BUILDING CODE OF AUSTRALIA COMPLIANCE ASSESSMENT REPORT

S.C.E.C.G.S. REDLANDS, CREMORNE CONCEPT PROPOSAL & STAGE 1 DEVELOPMENT APPLICATION

DATE ► 8.5.2015

REPORT NO. ► PROJECT 5419 - REV 03

Drawing No.	Revision
AR-DA-1101	A

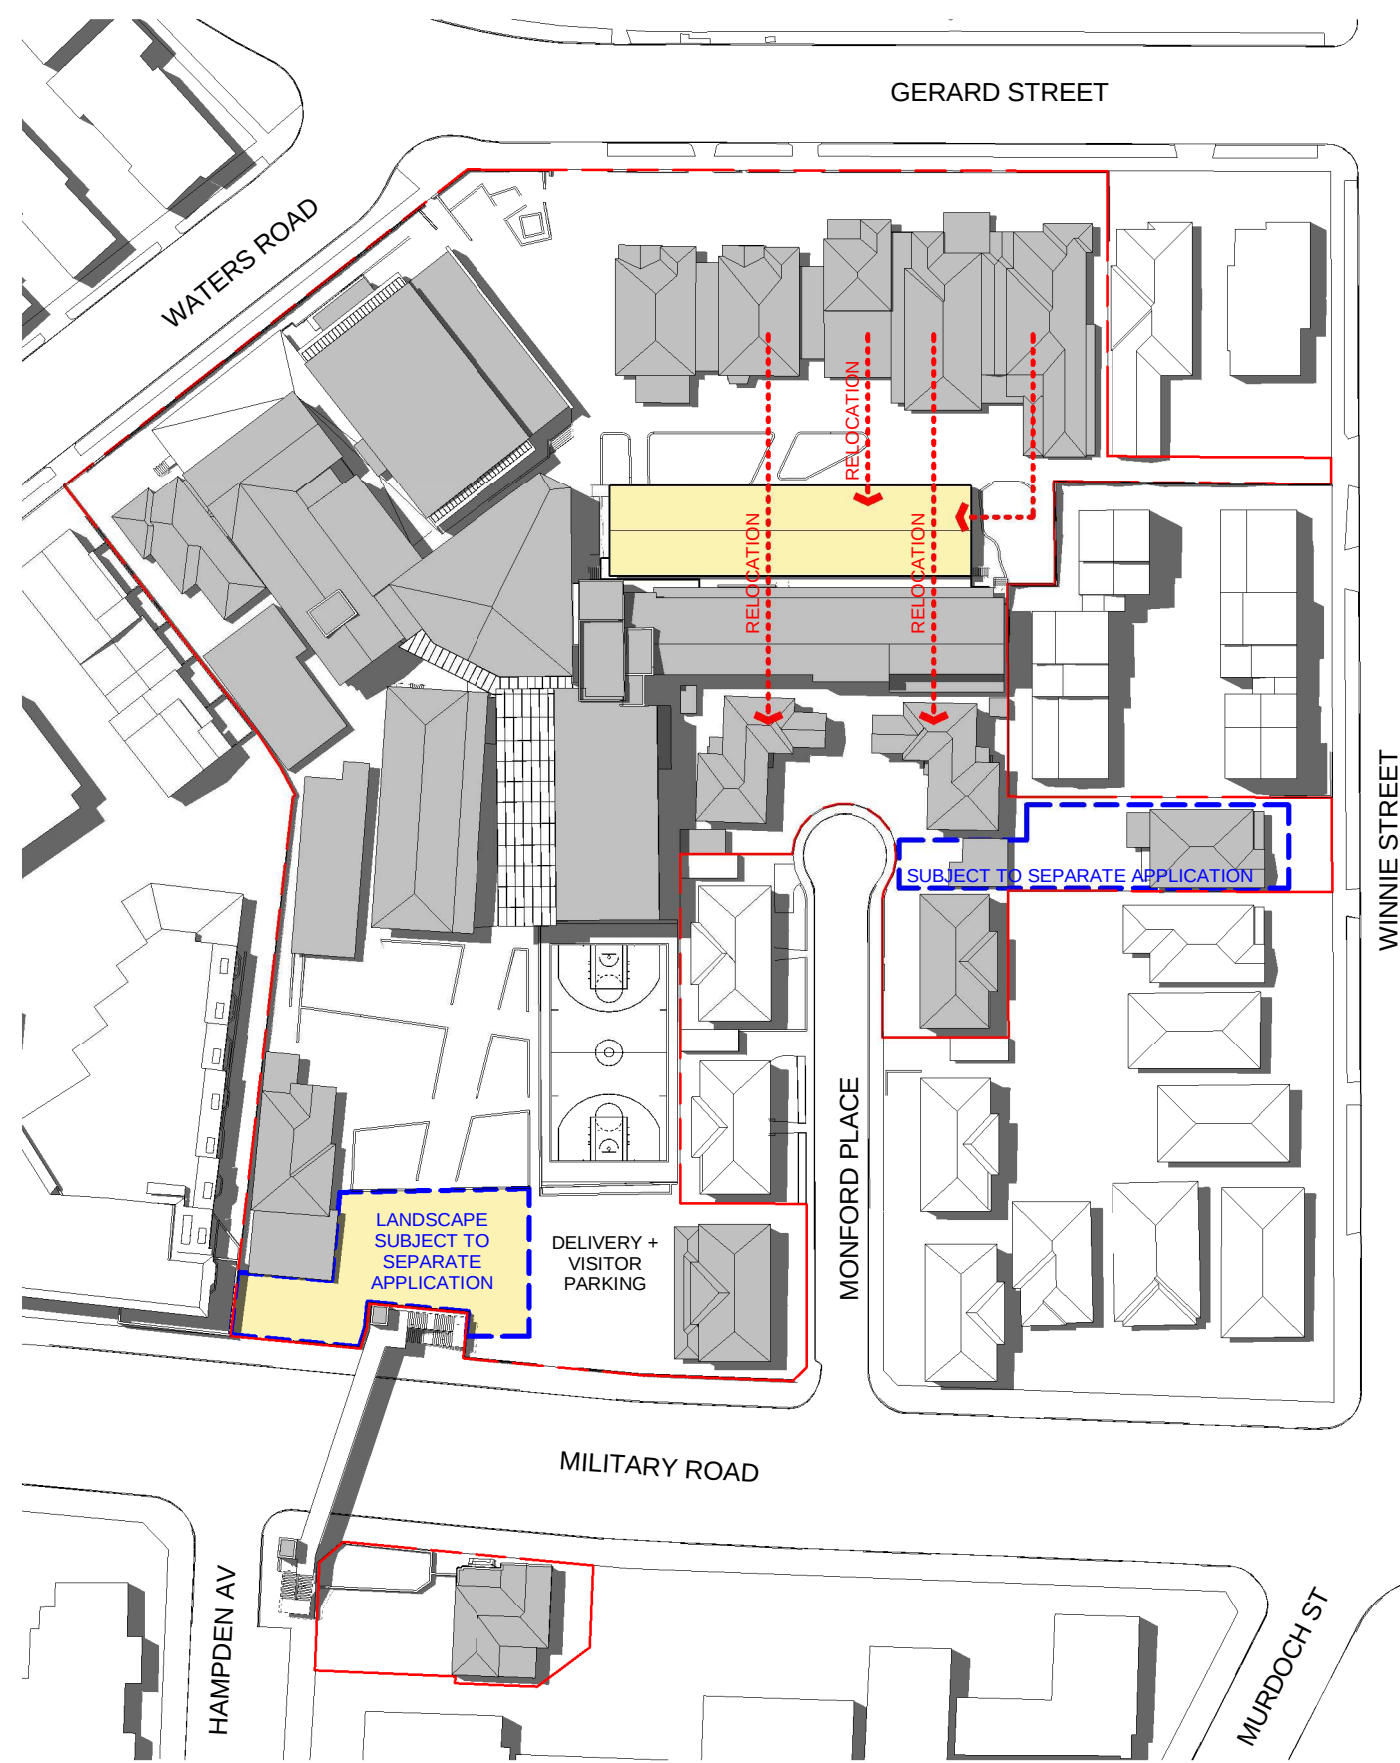
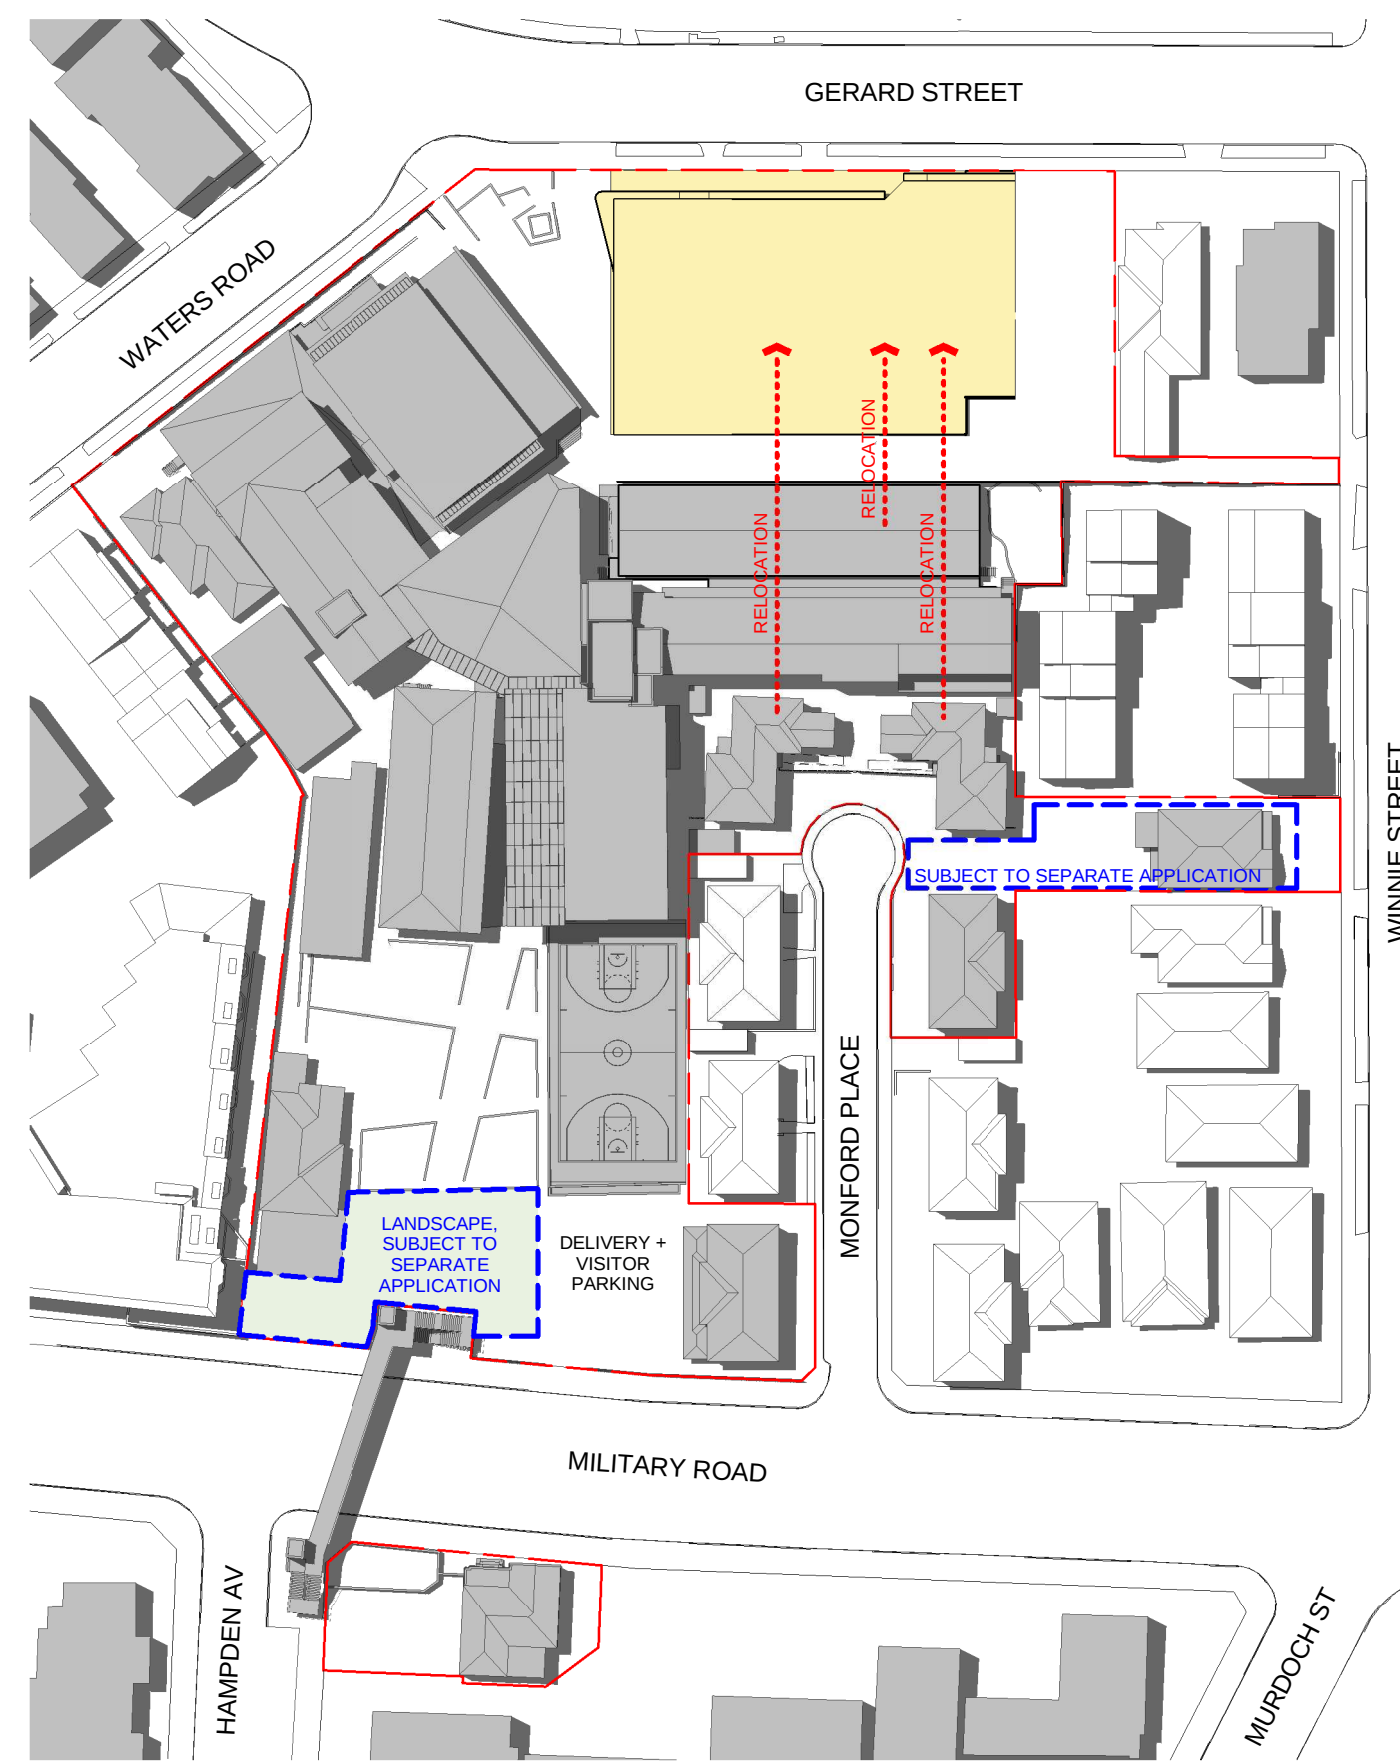
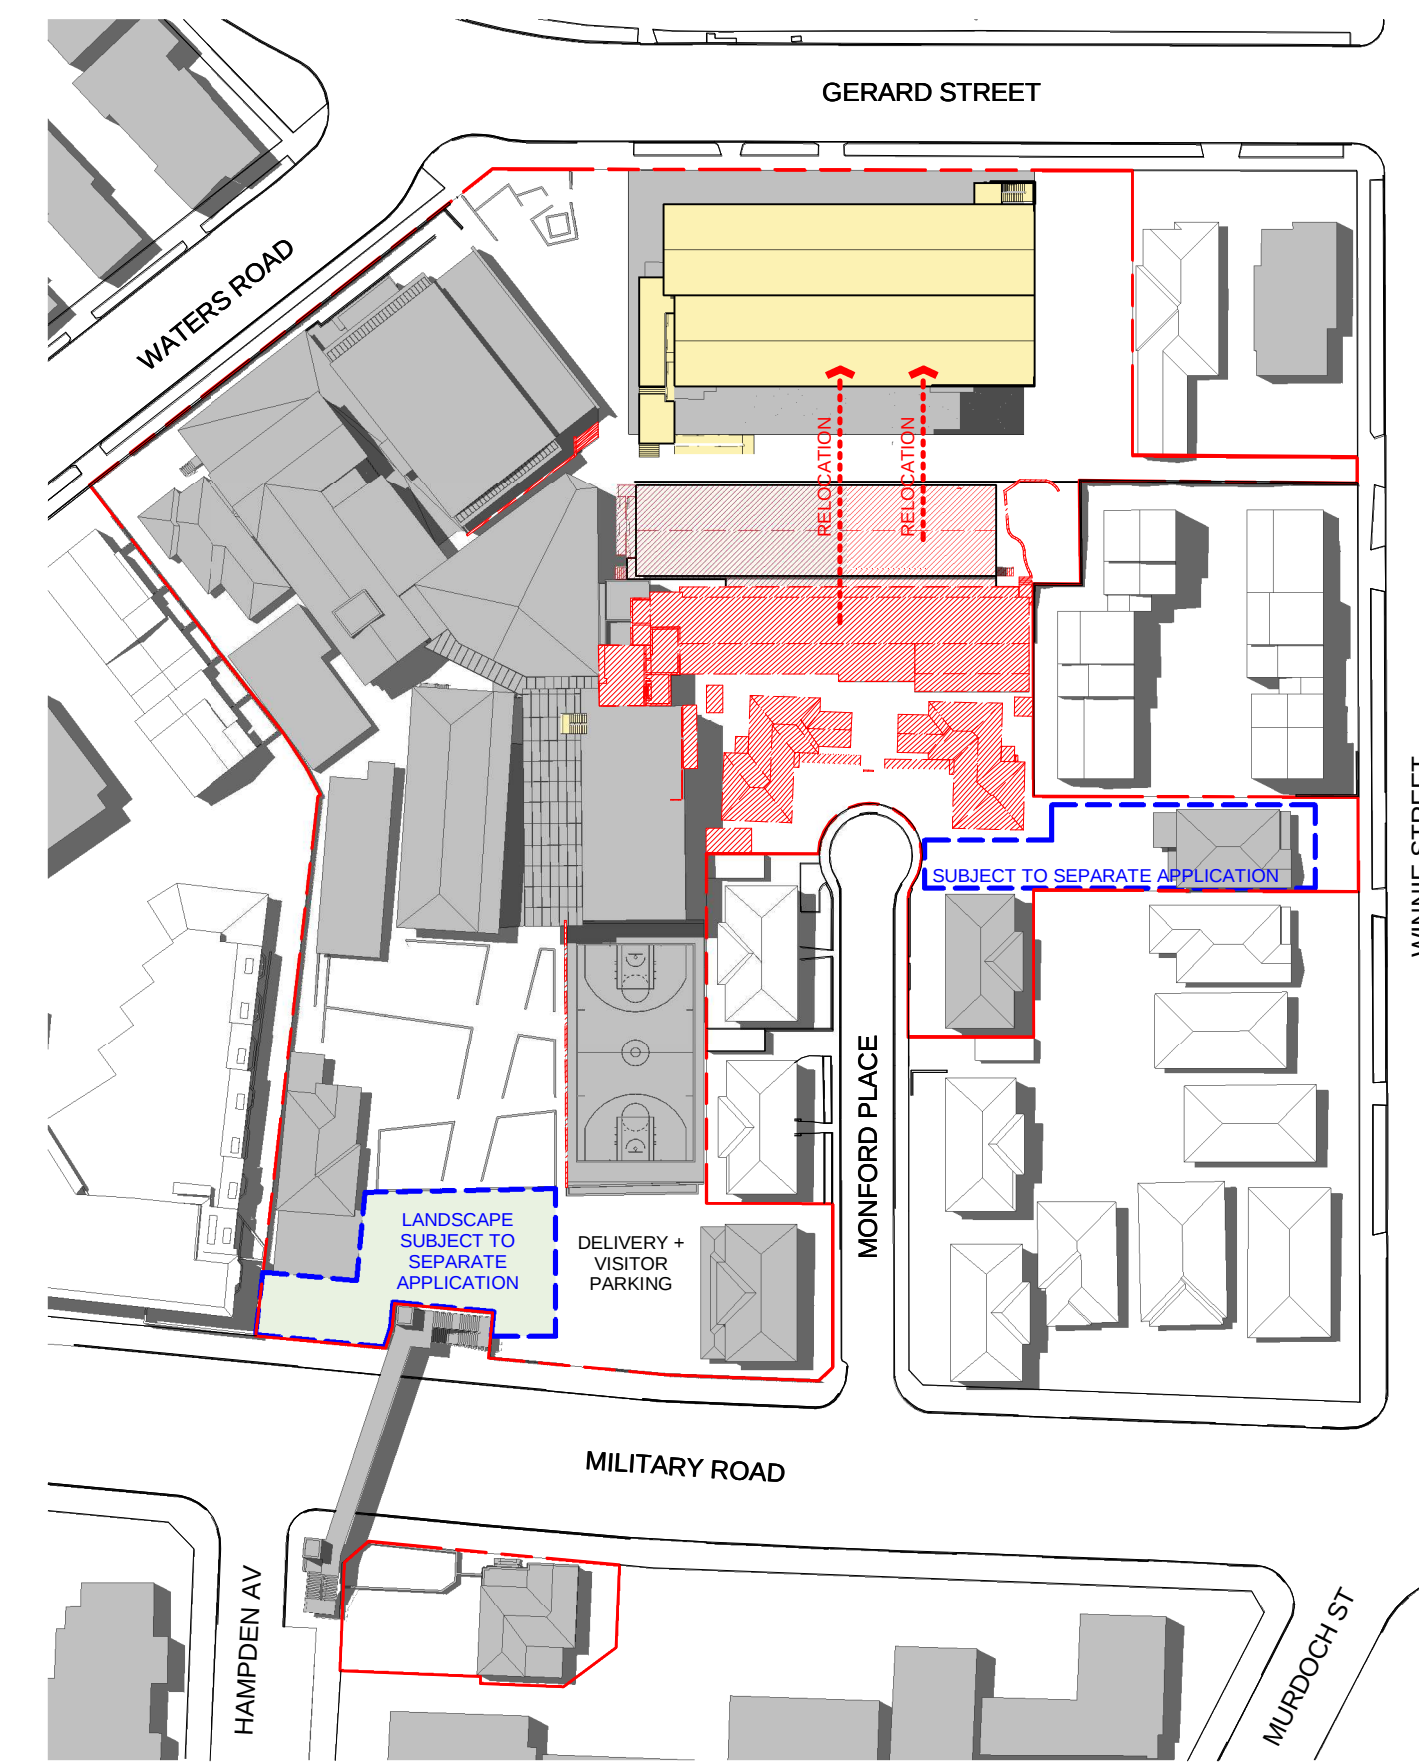
BCA Clause	Deemed-to-Satisfy Provision to be addressed
	<p>only (in lieu of fire rating loadbearing external wall parts);</p> <p>4. Stage 1C – During this stage the roof of the basement music area contains two skylights. Such skylights will be located directly beneath the temporary demountable classroom buildings to be positioned above. Such construction does not satisfy Specification C1.1, as an unprotected opening located within a separating floor.</p> <p><i>Details demonstrating compliance with this clause must be incorporated into the construction certificate plans / specification, or a fire engineered Alternative Building Solution must be attained.</i></p>
<p>C2.2 General Floor Area & Volume Limitations</p>	<p>Fire compartment floor area and volume limitations shall not exceed the following limitations set by Table C2.2:</p> <ul style="list-style-type: none"> ▪ Type A - Class 9b: 8,000 m² / 48,000 m³ ▪ Type B - Class 9b: 5,500 m² / 33,000 m³ <p>Based upon the Master Plan drawings dated March 2015, the largest fire compartment affecting the development occurs on Level 3 (as combines the Learning Hub education building, Roseby building, Humphery building and the Sports and Arts Centre building).</p> <p>This fire compartment approximates 5,200 m² / 15,600 m³, hence not more than the maximum permitted 8,000 m² or 48,000 m³, for Type A construction.</p> <p>Compliance issue –</p> <p>1. Notwithstanding the aforementioned the maximum permitted fire compartment size will be exceeded where Level 3 is linked to other levels via open stair shafts or via the two atrium wells located within the Learning Hub building.</p> <p>Hence fire wall construction must be introduced to reduce the size of fire compartments to comply with Table C2.2, <u>OR</u> fire engineered alternative solutions will be required relevant to the ability of the open stair shafts / atrium wells to provide adequate fire separation between storeys.</p>
